Planning Inspectorate

Issue Specific Hearing 2

Supplementary Agenda Additional Questions

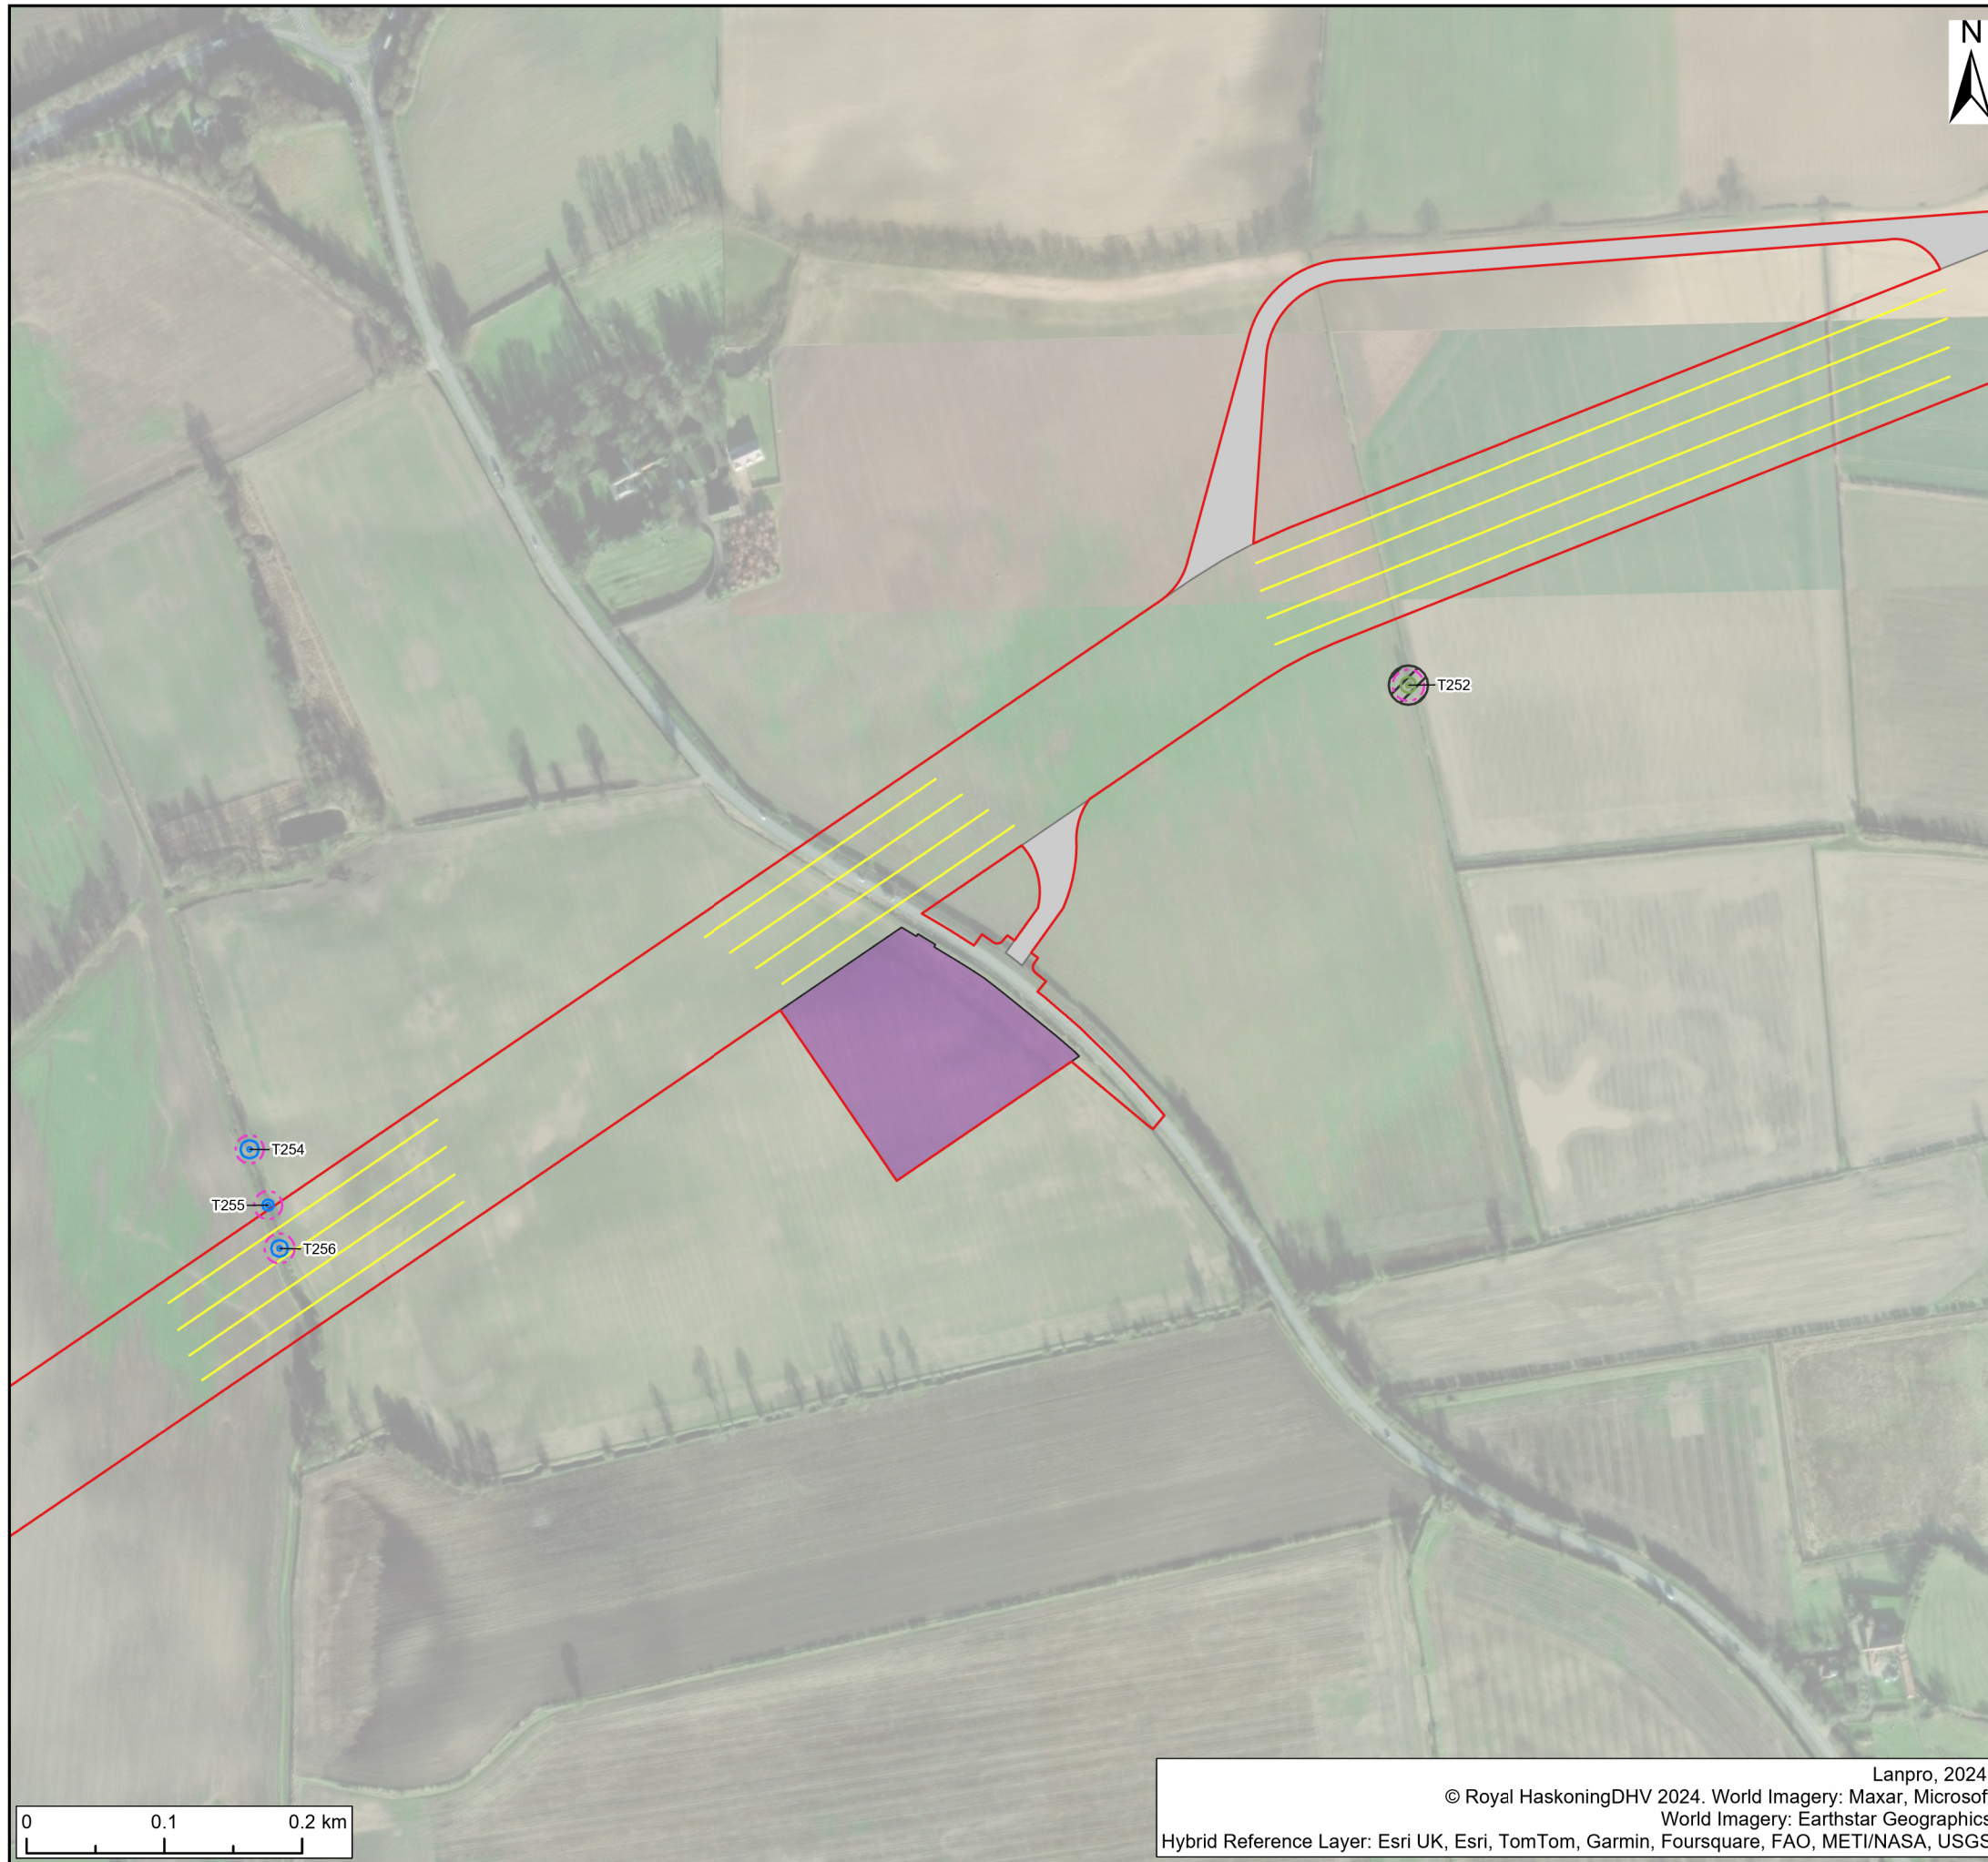
Agenda Item 12: Onshore Ecology			
ISH2.12.1	Proposed Trees and Hedgerows Removal	The Applicants	The line of trees identified as H0036 on page 14 of the Tree Preservation Order (TPO) and Hedgerows Plan (Rev 3) [AS-026] is shown for removal, whereas Sheet 10 of Appendix 5: Preliminary Tree Impact Plan of the Arboricultural Survey Report Preliminary Arboricultural Impact Assessment and Outline Arboricultural Method Statement (Rev 2) [AS-036 and AS-037] show the same line of trees to be retained through the use of trenchless crossing techniques. Could you clarify what is proposed here and update the documents accordingly?
ISH2.12.2	Proposed Trees and Hedgerows Removal	The Applicants	Sheet 11/12 of Appendix 5: Preliminary Tree Impact Plan of the Arboricultural Survey Report, Preliminary Arboricultural Impact Assessment and Outline Arboricultural Method Statement (Arboricultural Report) (Rev 2) [AS-036 and AS-037] shows the proposed removal of a number of trees (T151 to T166, and G37 and G38) at the crossing at Catwicks Head. However, on page 16 of the TPO and Hedgerows Plan (Rev 3) [AS-026], the crossing is only identified for the removal of hedgerows. Could you explain whether the use of trenchless crossing techniques would be more appropriate in this location?
